| Application number: 2020/91919   |  |
| What is the application for?:    | Demolition of existing supermarket and erection of block of 6 flats with associa |
| Address of the site or building: | The Co Operative Food, 19, Northgate, Almondbury, Huddersfield, HD5 8RX          |

| Type of comment: An objection  |

PROPOSED FIRST FLOOR PLAN

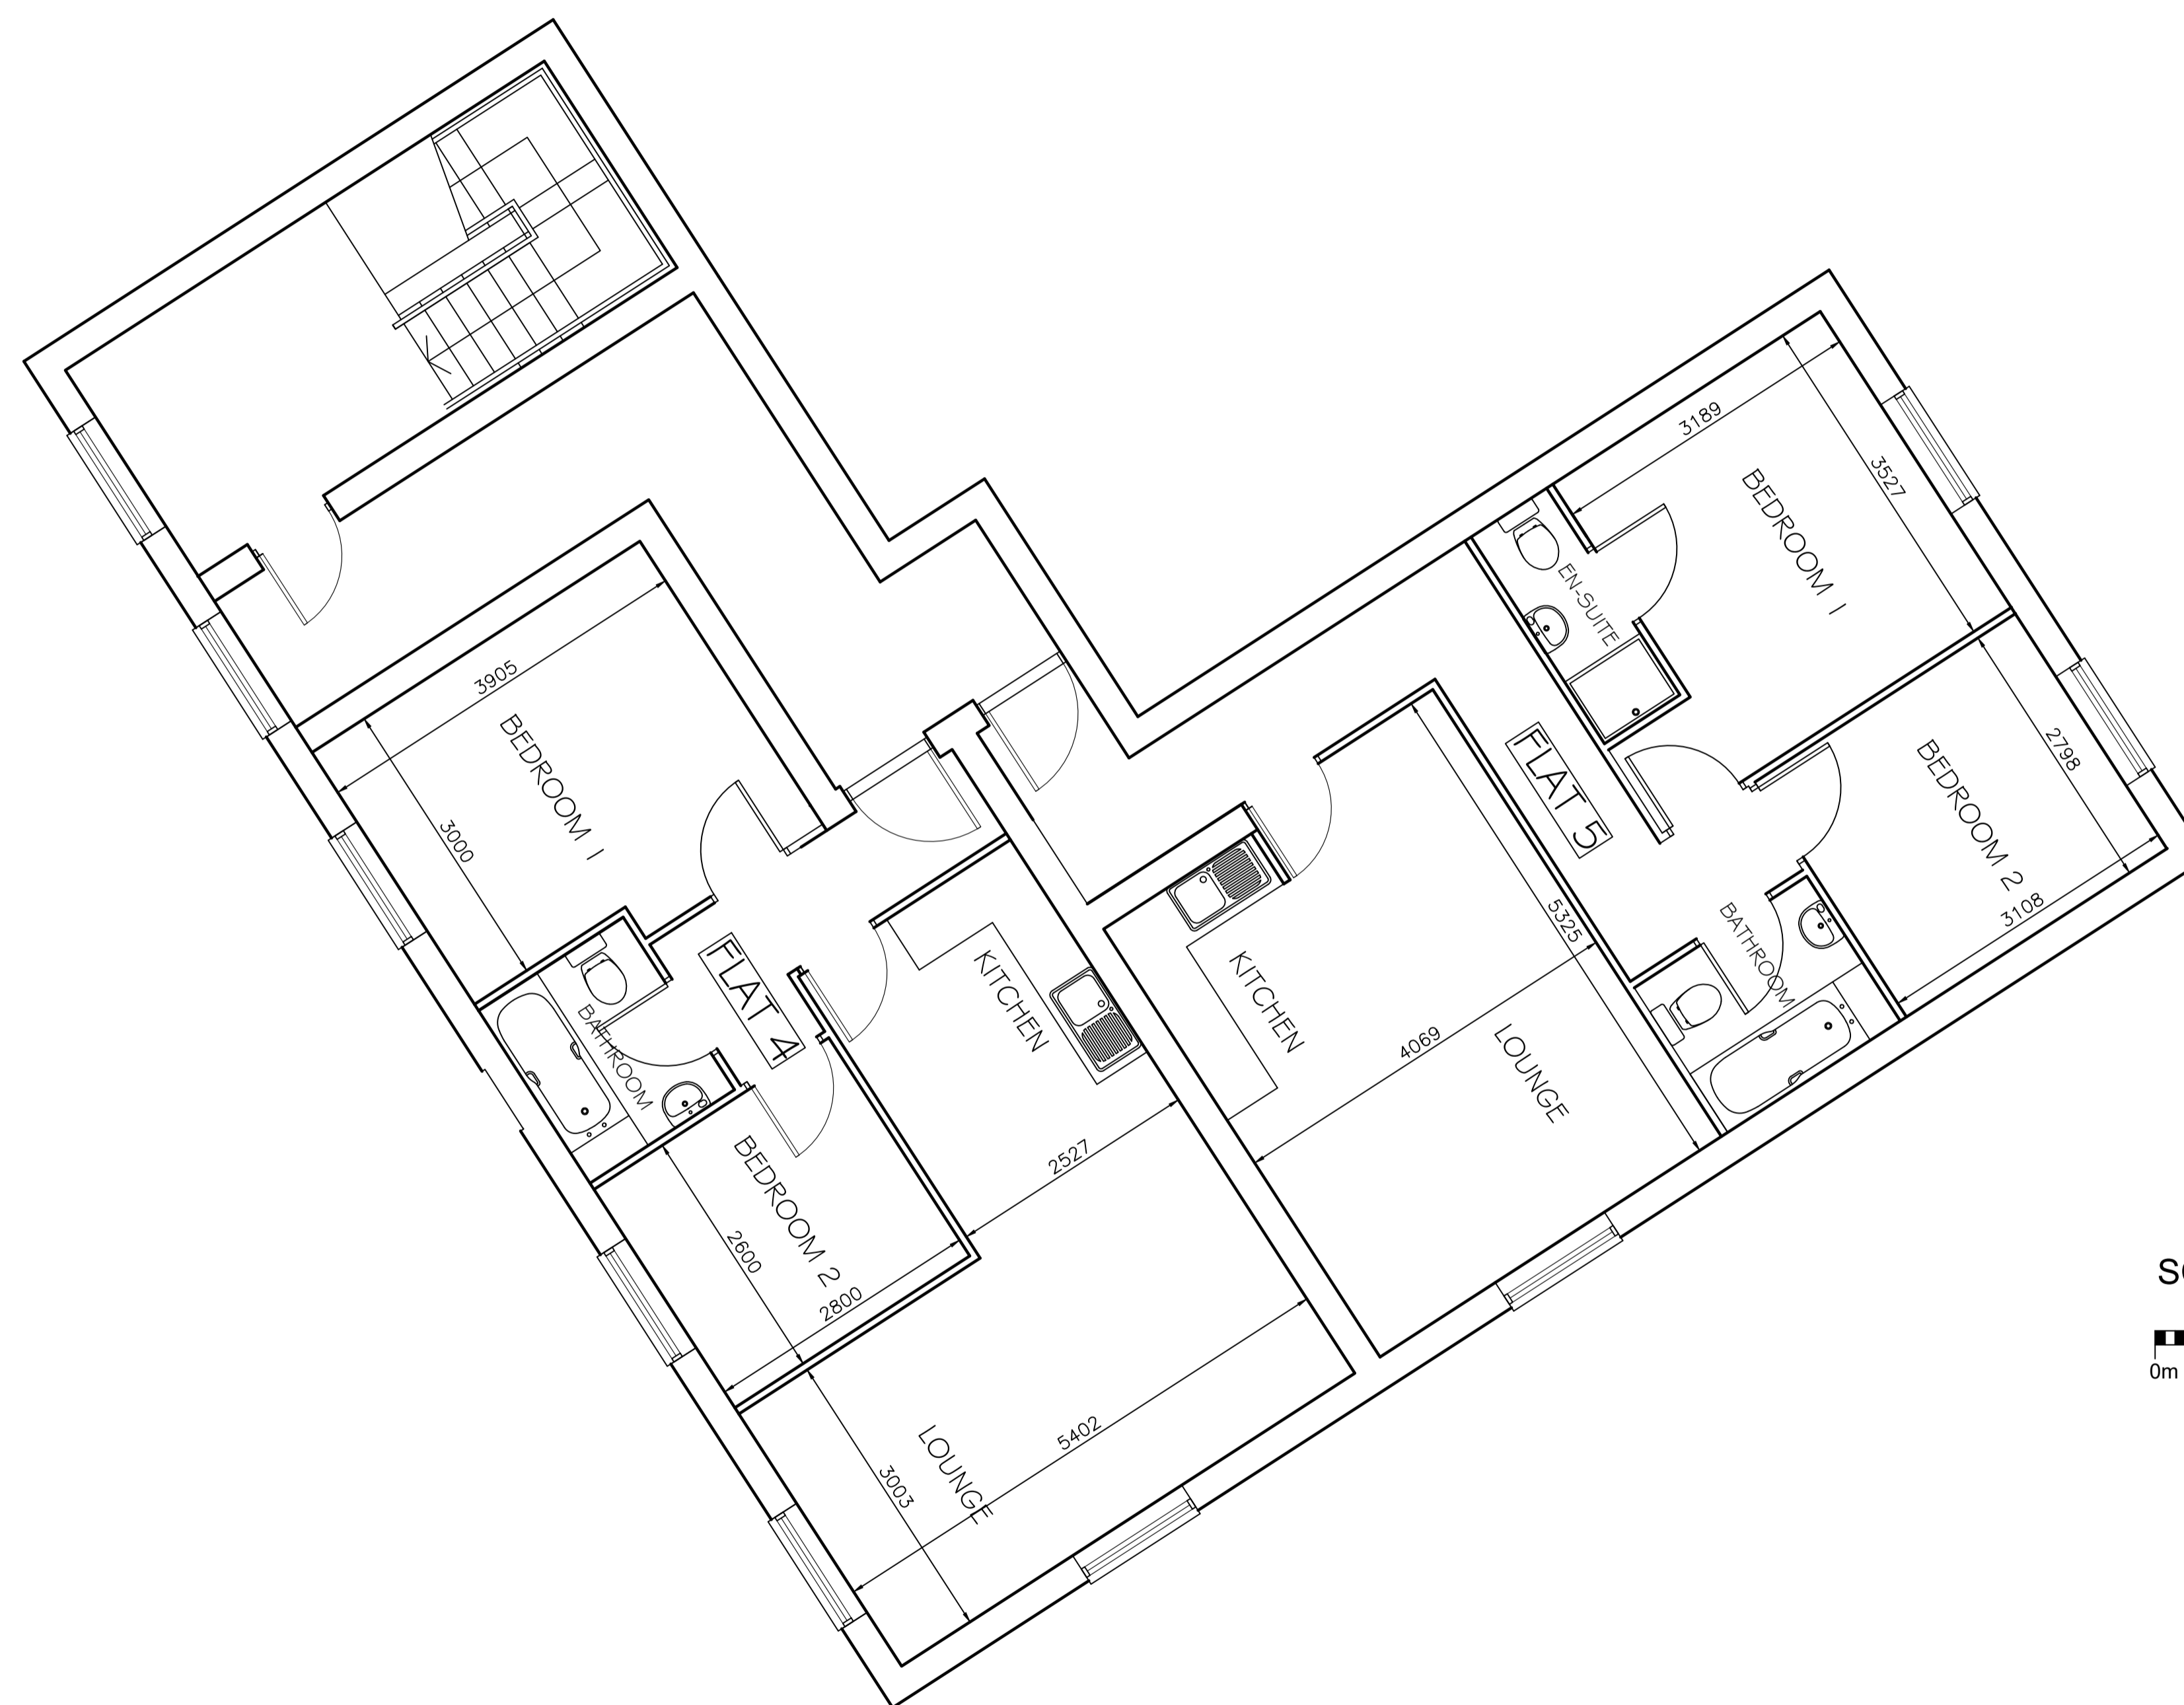
| <p>Good morning. The plans for flats at the location suggest that there will be a number of windows overlooking my property. Because of the height of the land and the flats, residents would be able to see directly into my house, probably at both levels and the flats would be very close to my property. The flats will also directly overlook my</p> <p>In addition building a two storey building in that location is likely to block light completely at my property and that of my neighbour. I am concerned for my privacy and for the quality of life in my home if this plan were to go ahead. Kind regards</p> |
